**Hunter Power Project (Kurri Kurri Power Station) (SSI-12590060) – Review of Environmental Impact Statement**

BCD has reviewed the Environmental Impact Statement (EIS) including its appendices for this project in relation to site constraints including biodiversity and flooding.

### Hunter Power Project (Kurri Kurri Power Station) (SSI-12590060) – Review of EIS

Figure 5.1: Indicative depths of excavations and groundwater (two scenarios)

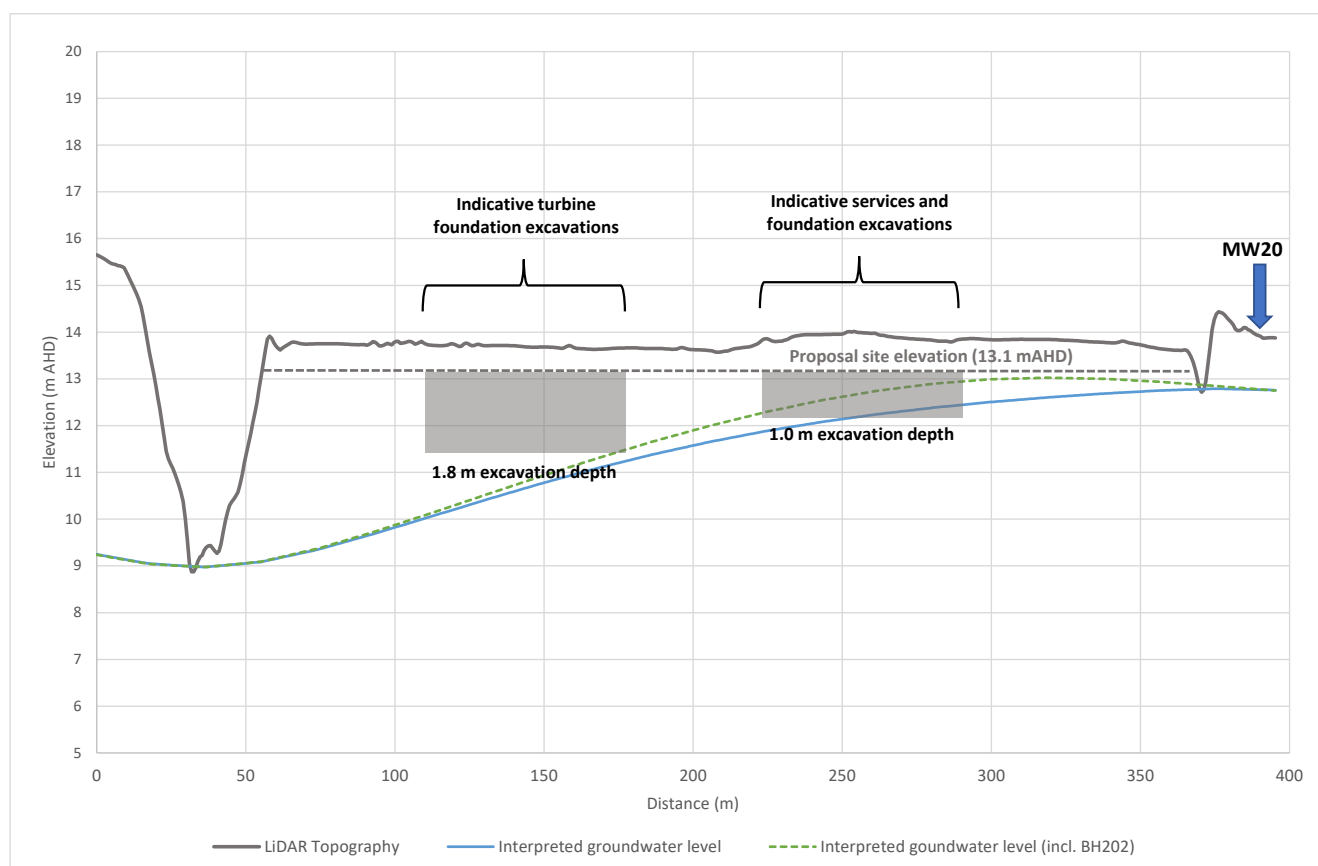
Figure 5.1 shows the likely interaction between the footings of the development and the water table during construction. This figure does not show the foundations for the turbine which are noted to be 18m deep. This has not been addressed in the report.

The impact of water table on infrastructure during construction and post construction has not been adequately assessed. In particular, how groundwater affects the construction and operation of the on-site detention pond requires greater consideration.

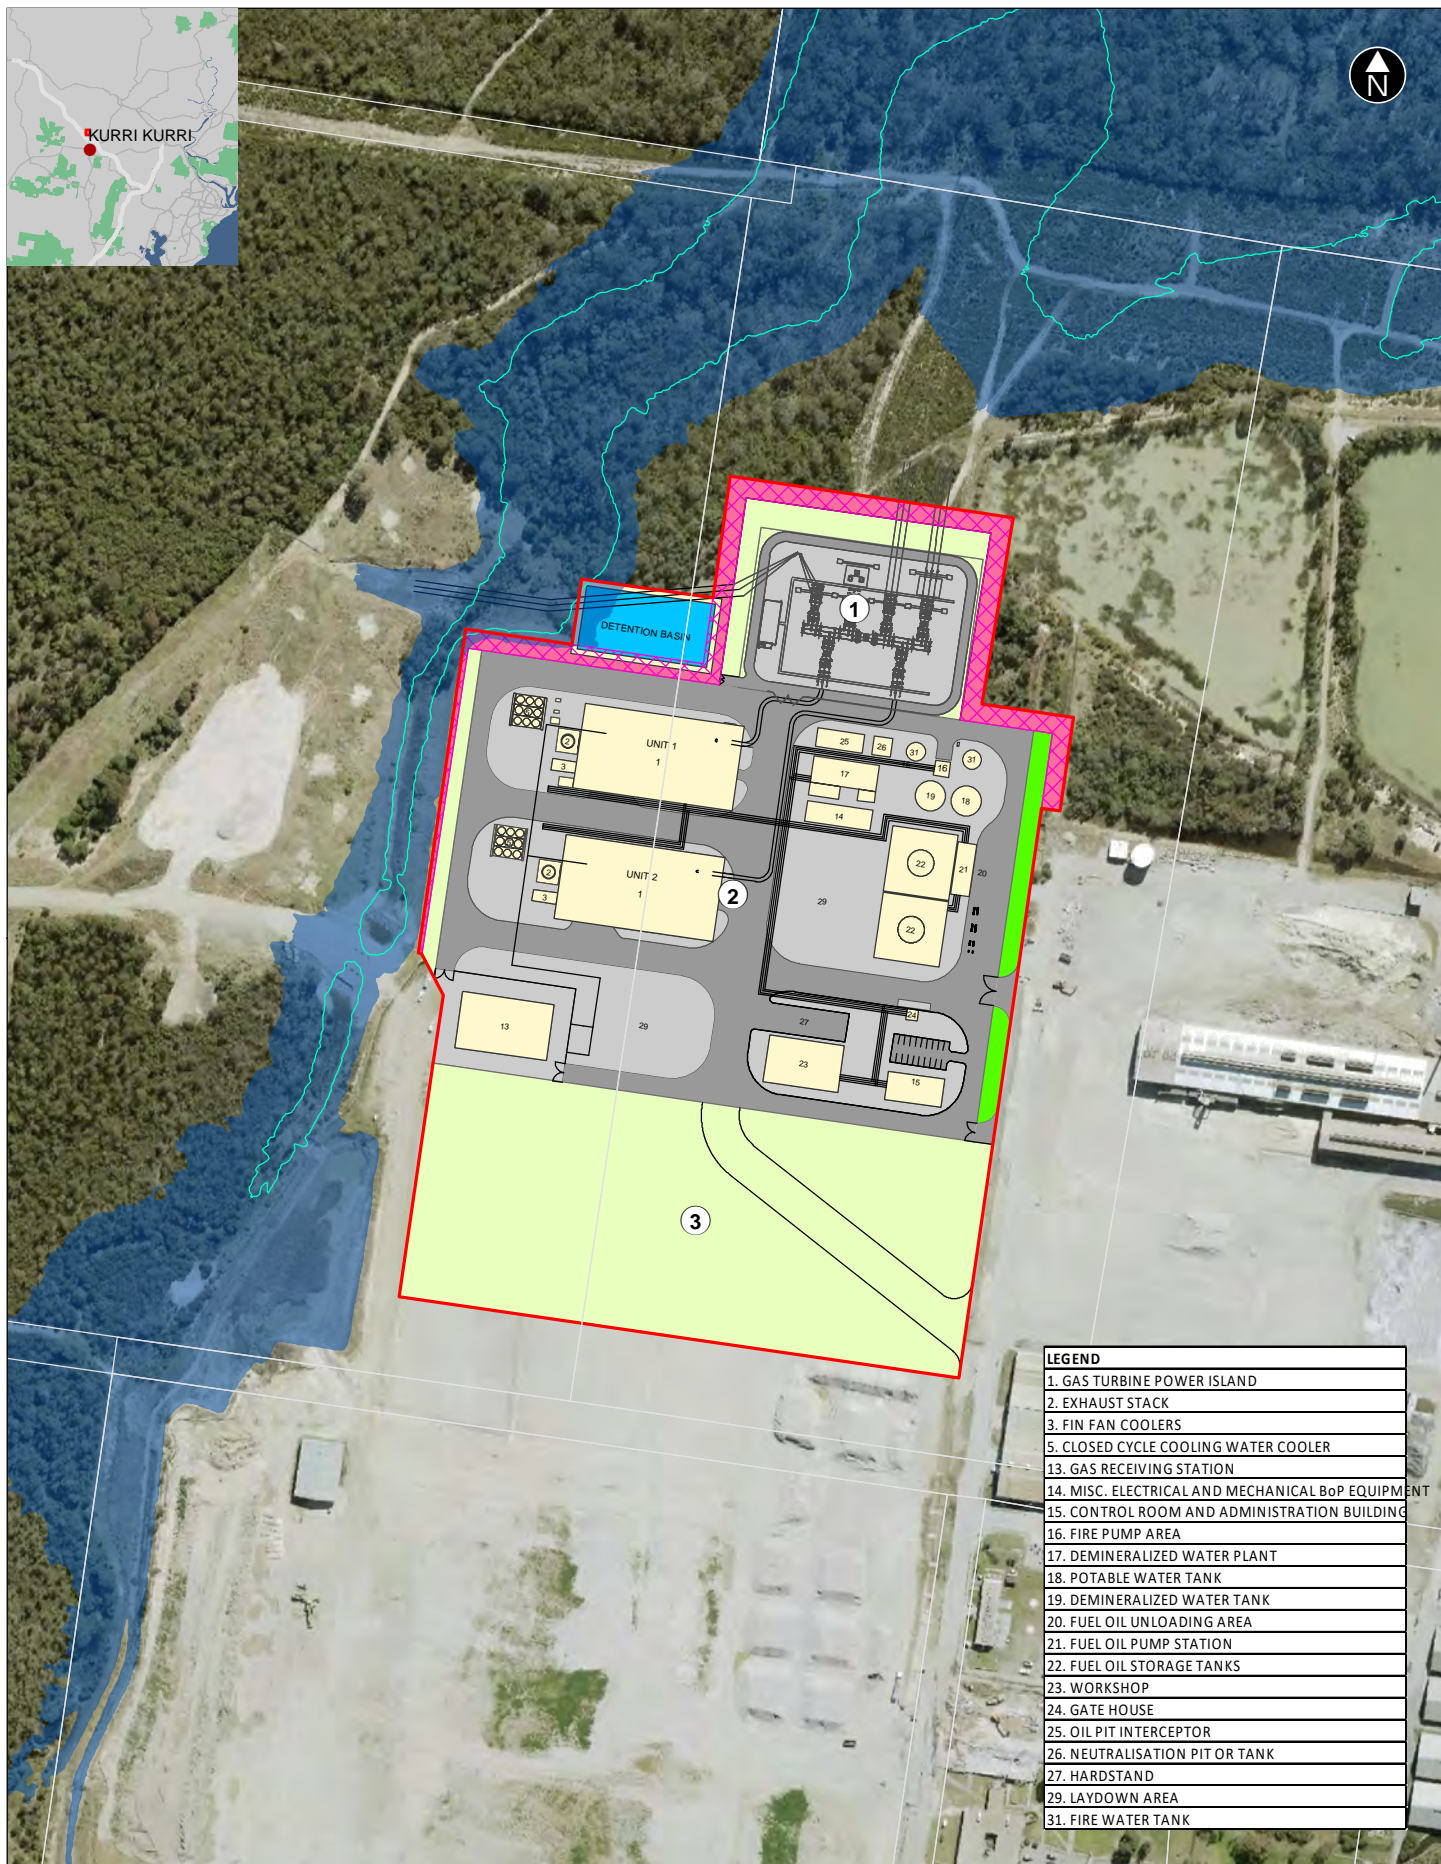
The hydrology assessment indicates that the site is flood fringe and will have no impact on flooding offsite. The source of the flood categorisation information quoted in the EIS is not provided and it is not clear how it has been determined that there will be nil flooding impacts. The site plan indicates that the development site includes a tributary of Black Waterholes Creek and the edge of an existing on-site dam. The impacts of the proposed works to these features is not addressed and insufficient information has been provided regarding the existing and proposed levels of the development for issues associated with the development to be determined. Figure 1.2 and 1.3 in the hydrology assessment indicates that the development footprint will encroach into the adjacent tributary of Black Waterholes Creek. The on-site detention (OSD) pond appears to encroach on the 1% Annual Exceedance Probability (AEP)

flood extent and appears to be partially inundated in the Probable Maximum Flood (PMF) (Figure 4.6). The impact of flooding on the proposed OSD basin has not been assessed.

The determination of nil flood impact made in the hydrology report should be justified. If the development encroaches into the flood plain, a flood impact assessment should be prepared. The impact of flooding on the proposed OSD basin should also be assessed.
